From: Amanda Scholes on behalf of Planning.Responses
Sent: 05 May 2017 08:55
To: Planning Scanning
Subject: FW: 86 Annandale Avenue - BR/74/17/PL

2nd Highway comments

Site & Block Plan.

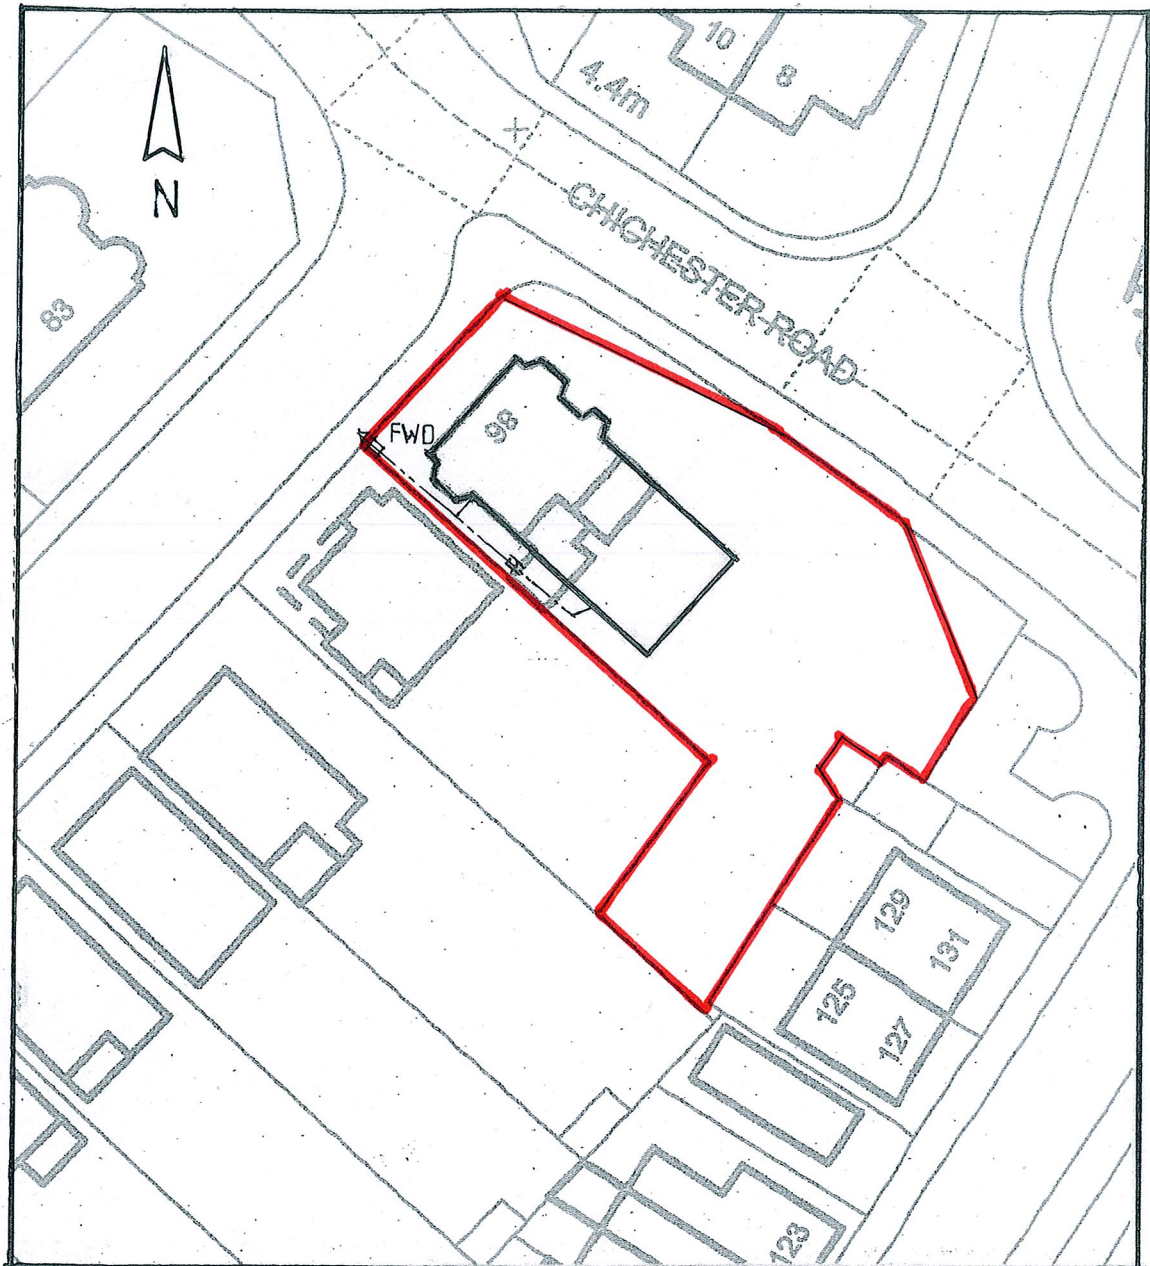
Thank you for this additional information. Three flats total will be in place if the proposal were to be permitted with the existing off street car parking area being utilised. No plans have been provided demonstrating the quantity of spaces available and the allocation of these to the proposed and existing flat. Nevertheless, our previous comments apply whereby any overspill parking on street could not take place in locations that would be detrimental to highway safety due to comprehensive junction protection markings.

If the LPA were minded to approve the application, I would advise a condition securing bicycle storage.

The existing off street parking will be used and the first floor is a 2 bed flat.
If WSCC require a bike store then there is ample space to provide one.
